May 15, 2015

Memo To: Barbara Barhydt
Jean Fraser
From: David Margolis-Pineo
Re: Review Comments for the Neighborhood Center – 1342 Congress St (2015-058)

C-2B

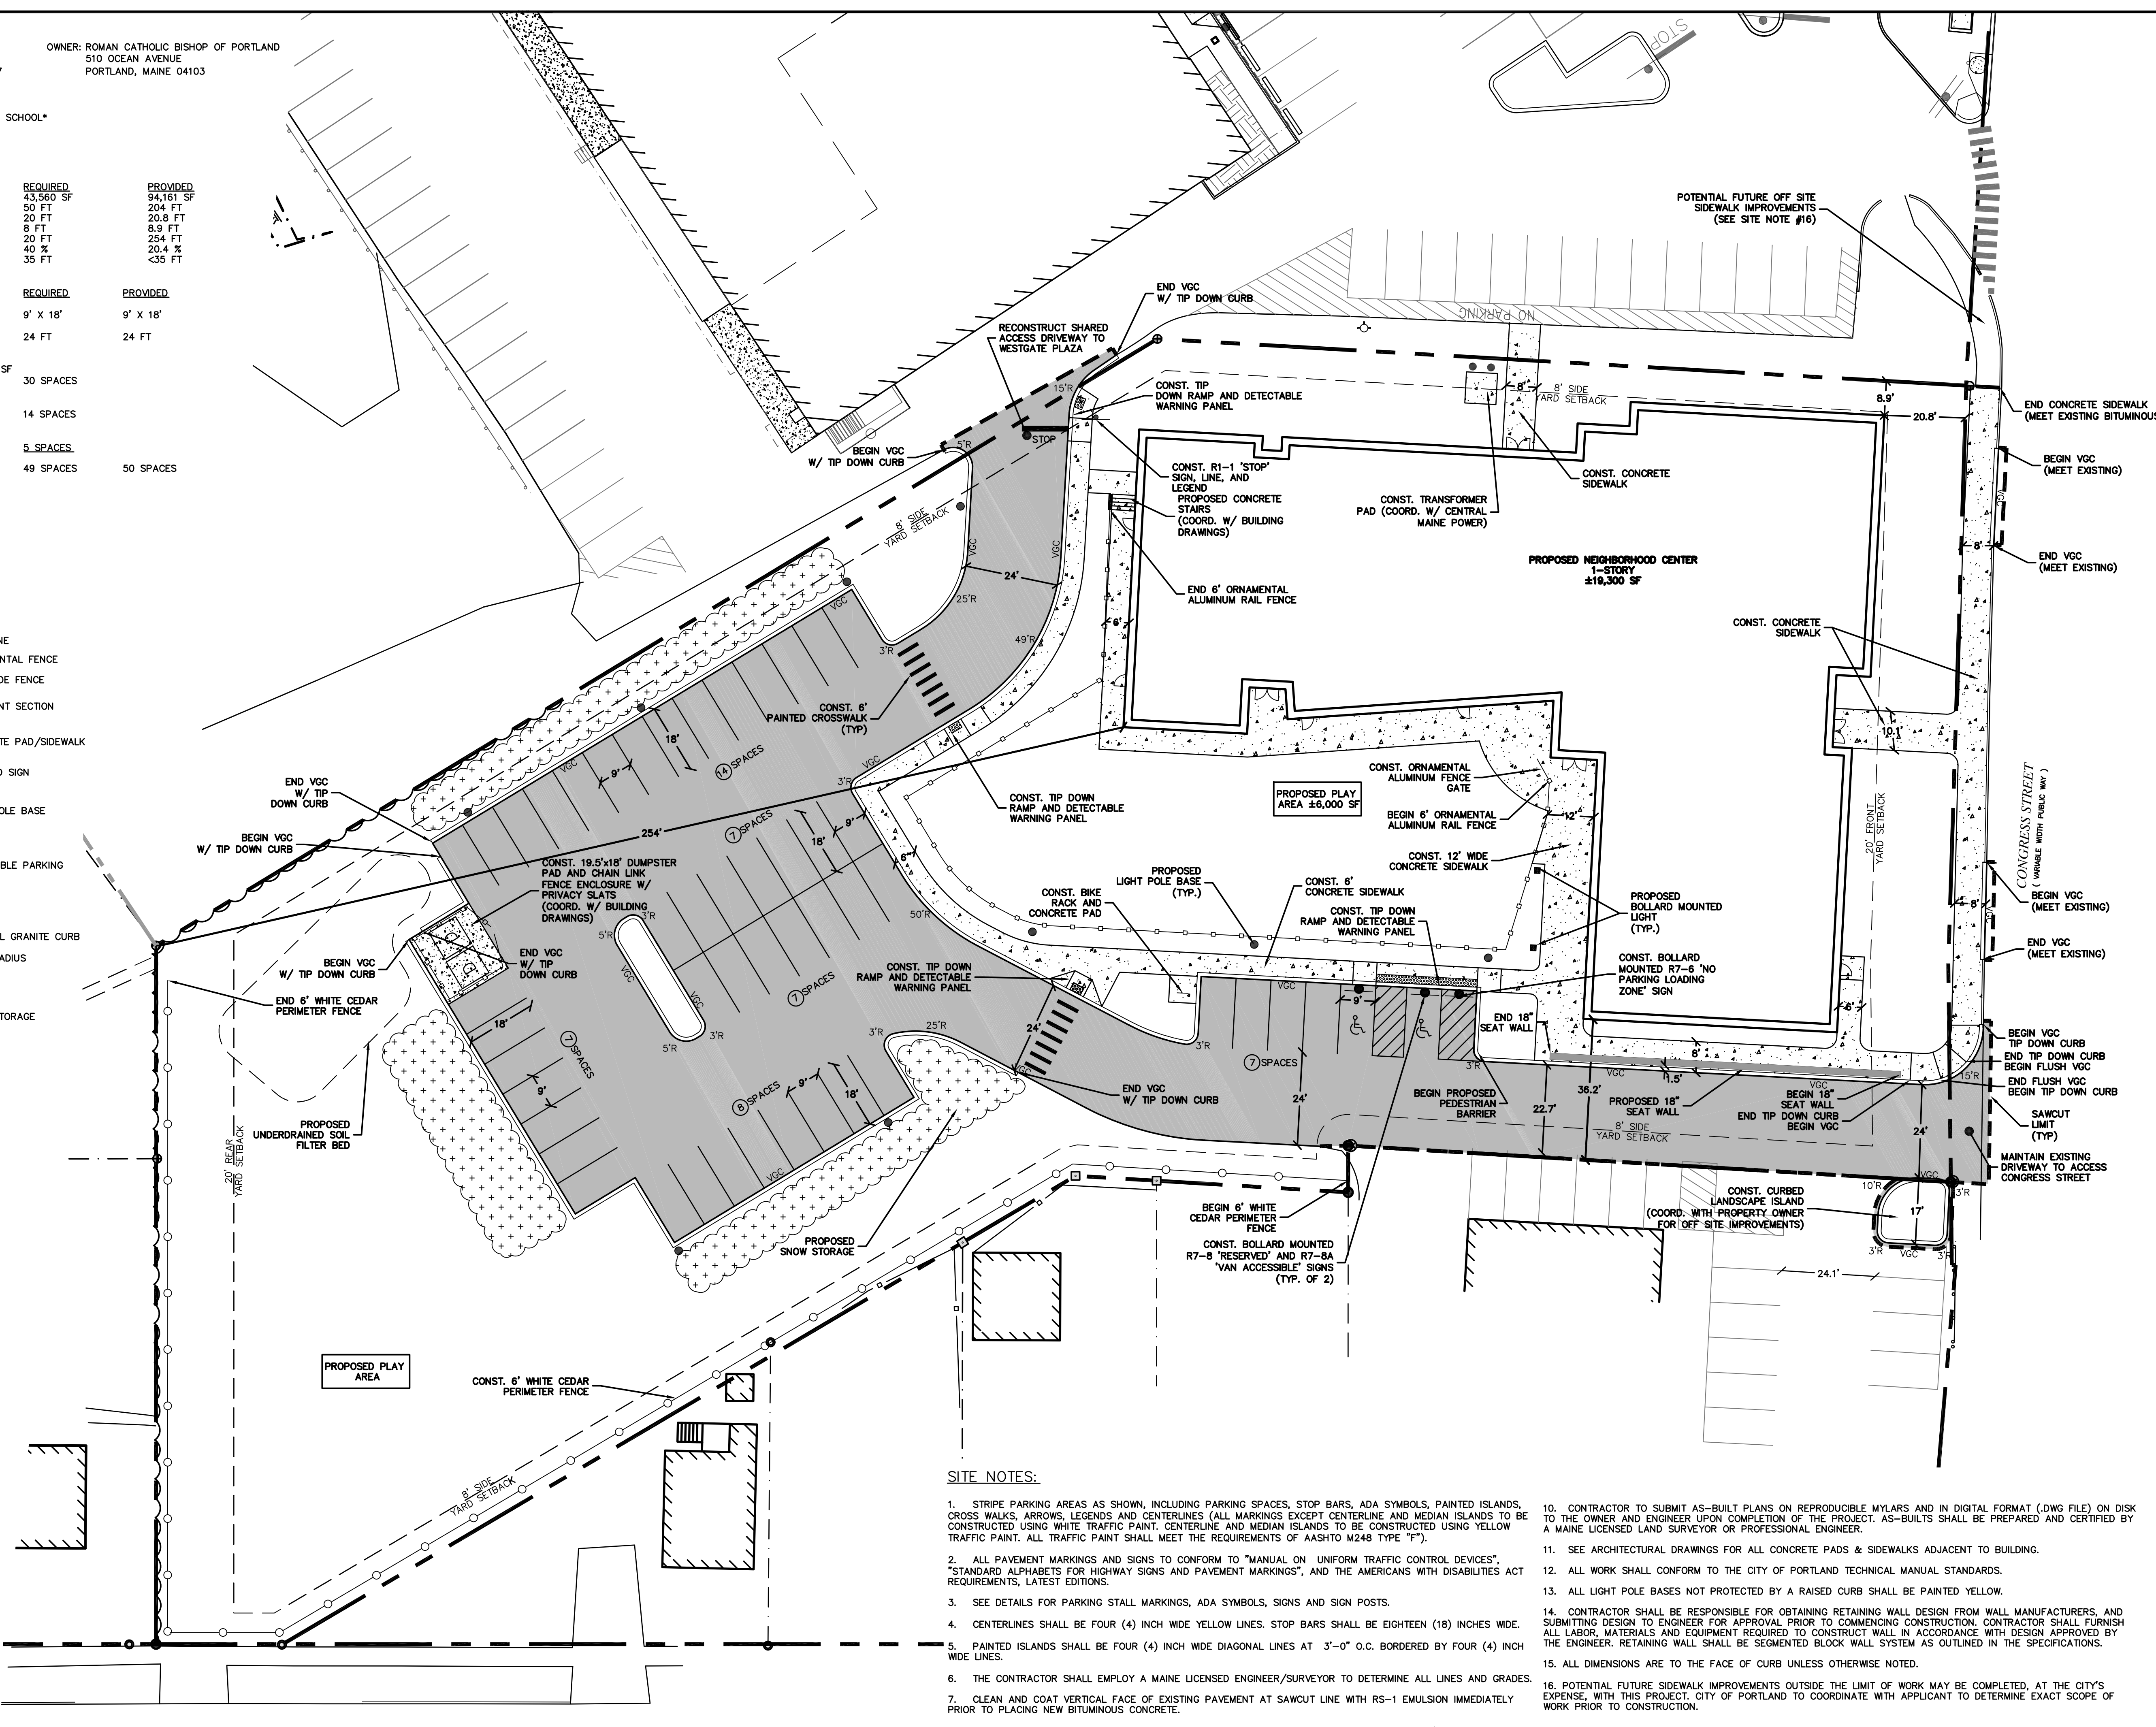
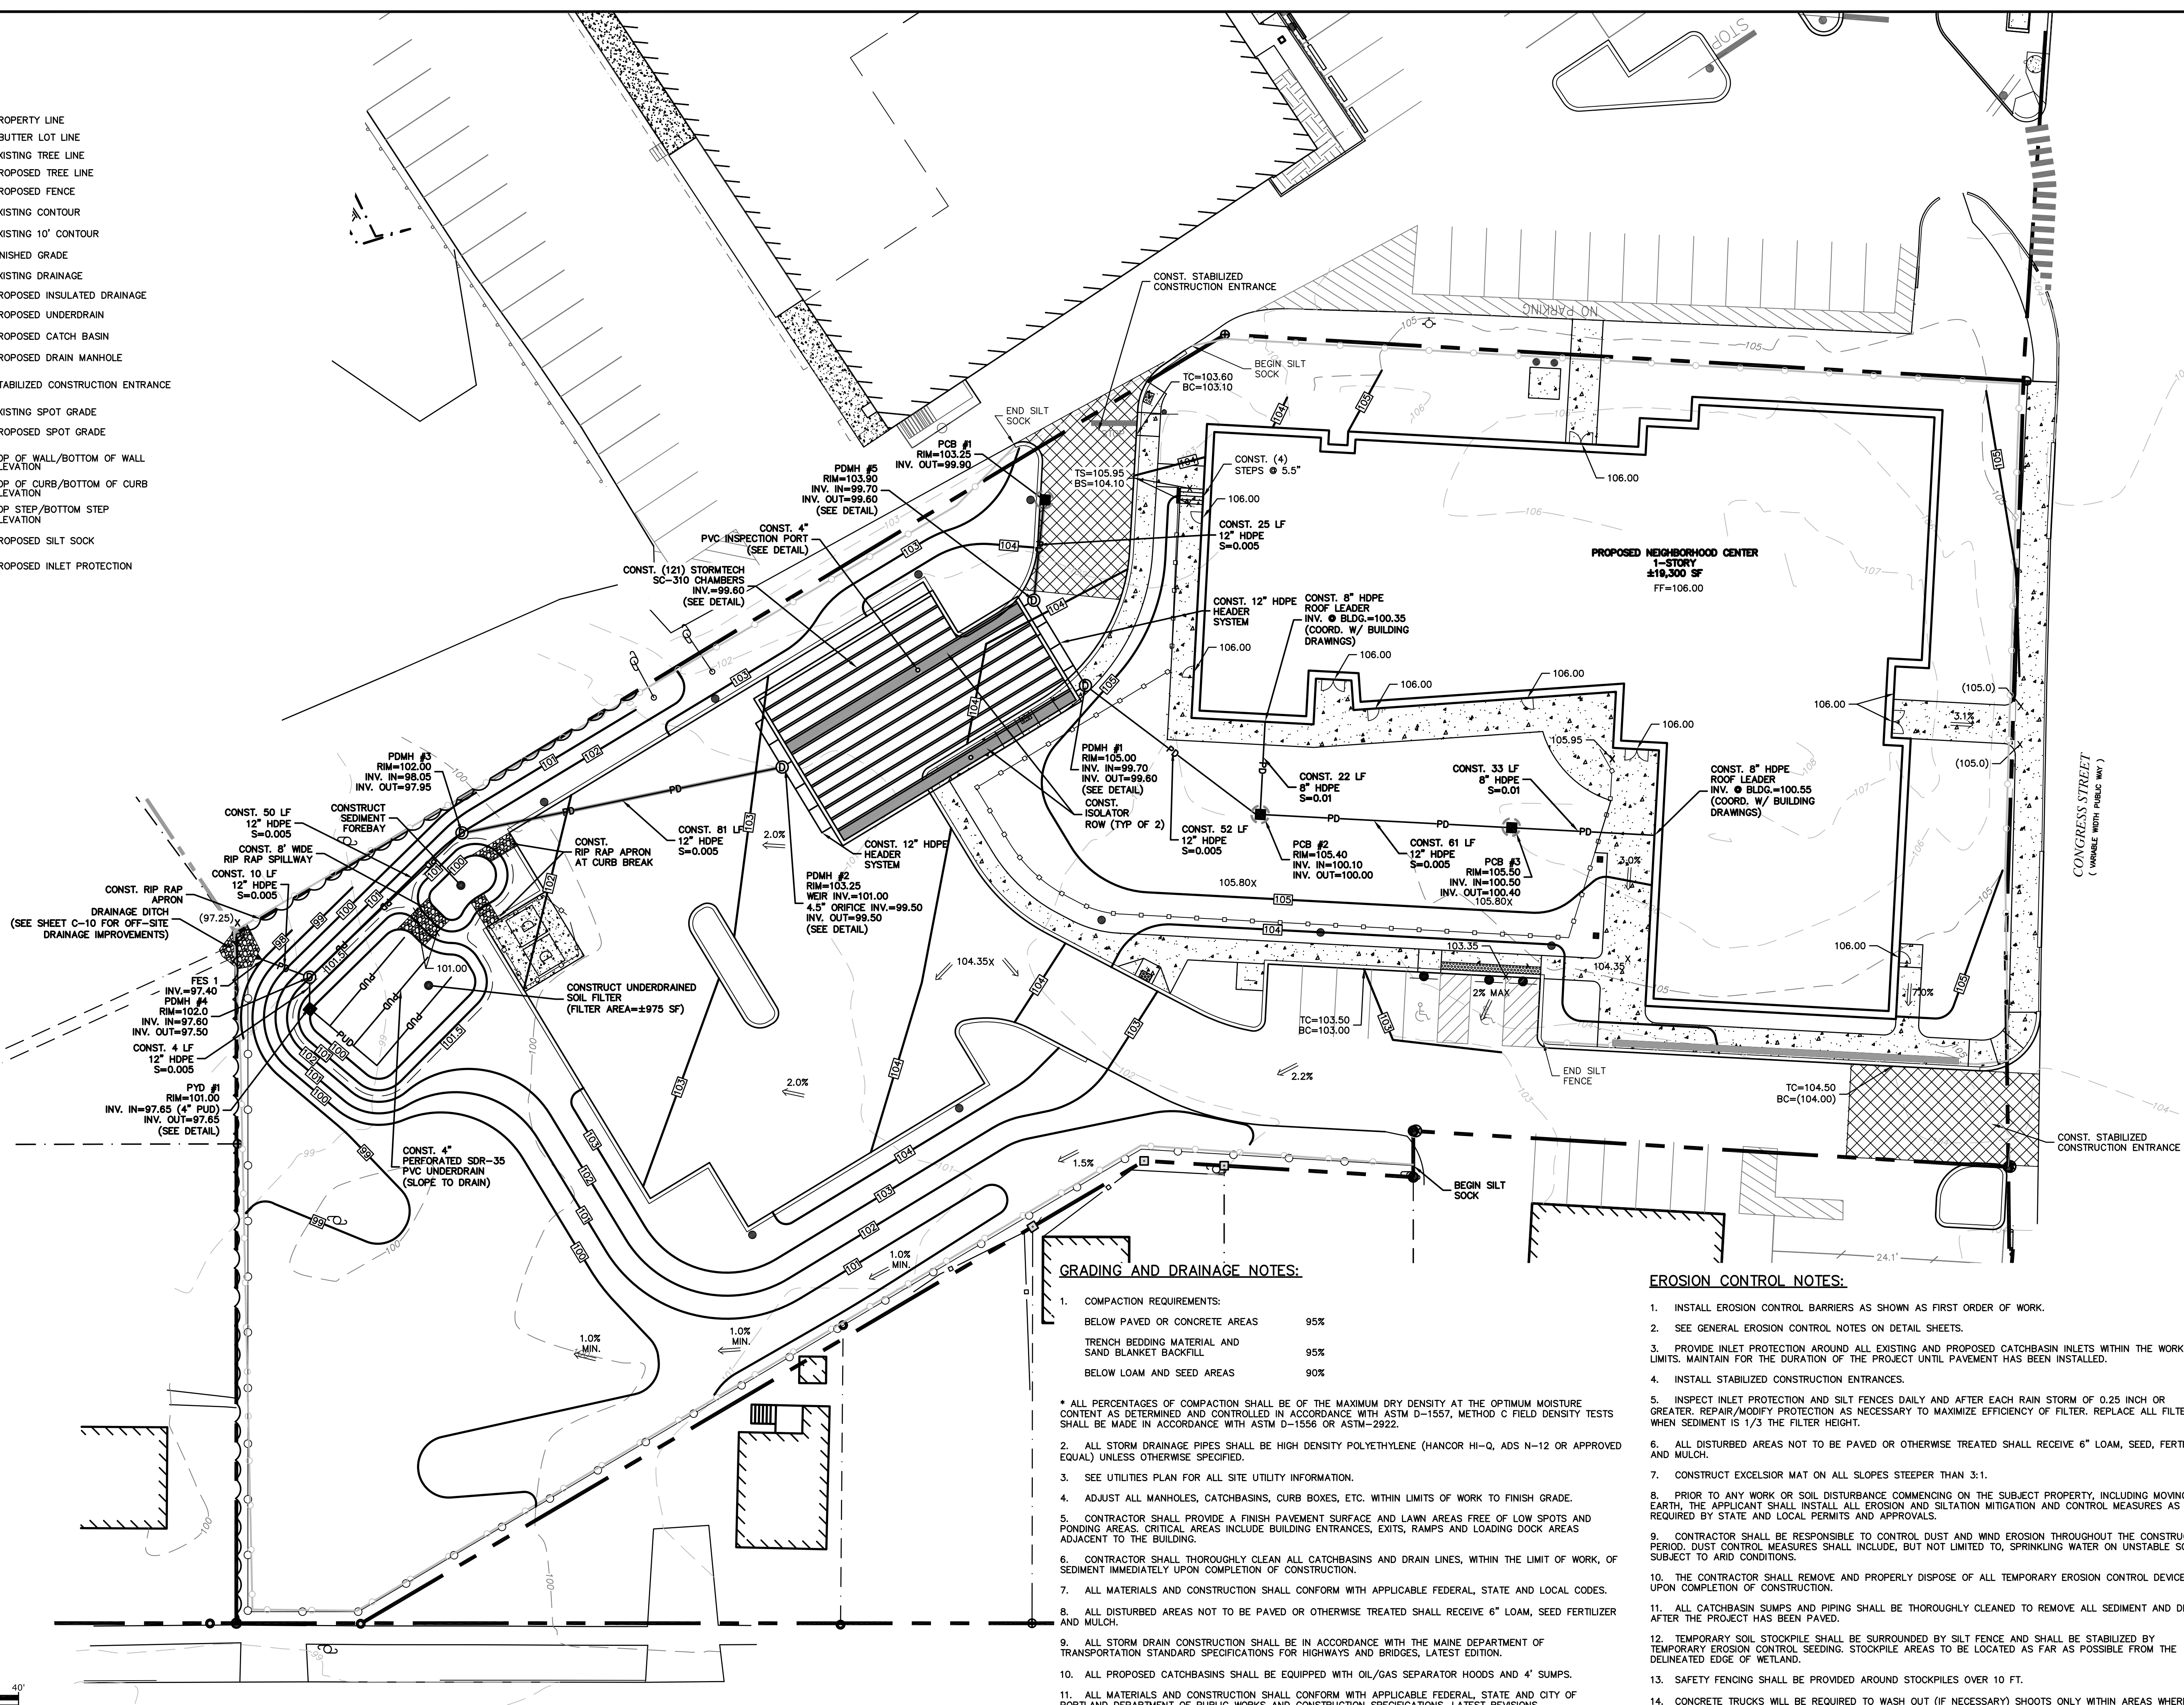
5. Please modify note 12 on sheet C-2B to read, “All work shall conform to the City of Portland Technical Manual standards.”
6. The catchbasin outlet control device referred to as “The Snout” is an acceptable alternative to the Casco Trap.

1,000 GALLON GREASE TRAP
NOT TO SCALE

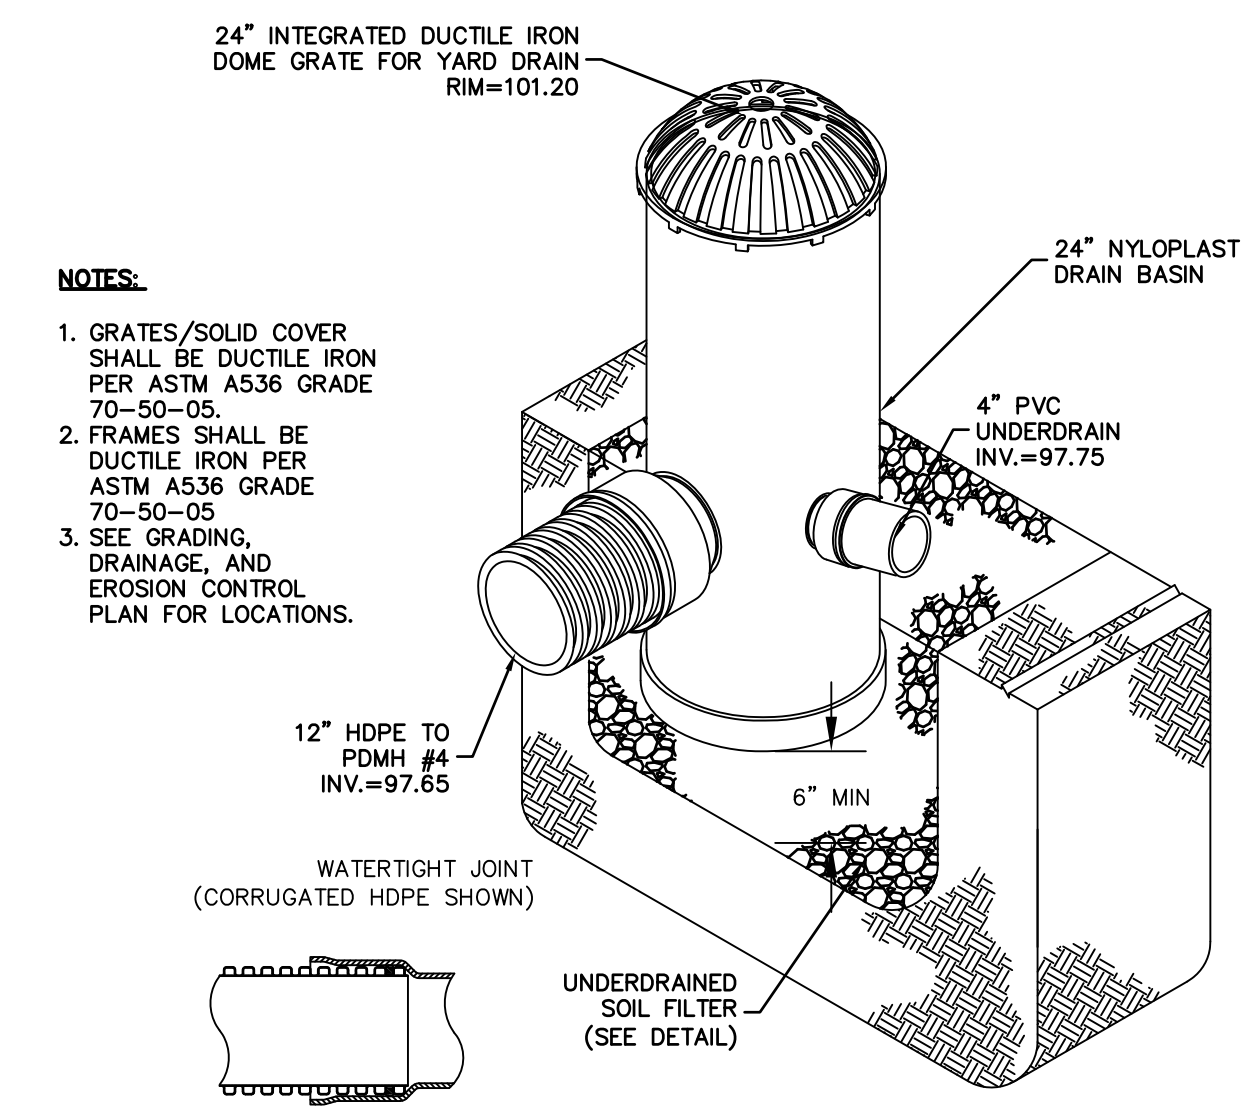
8. Only sanitary wasted is allowed to be discharged to the City’s sewer. No roof, site drainage or any other non-contaminated water is allowed.
9. Please provide a detail of the proposed grease trap. Please see Portland Technical Manual.
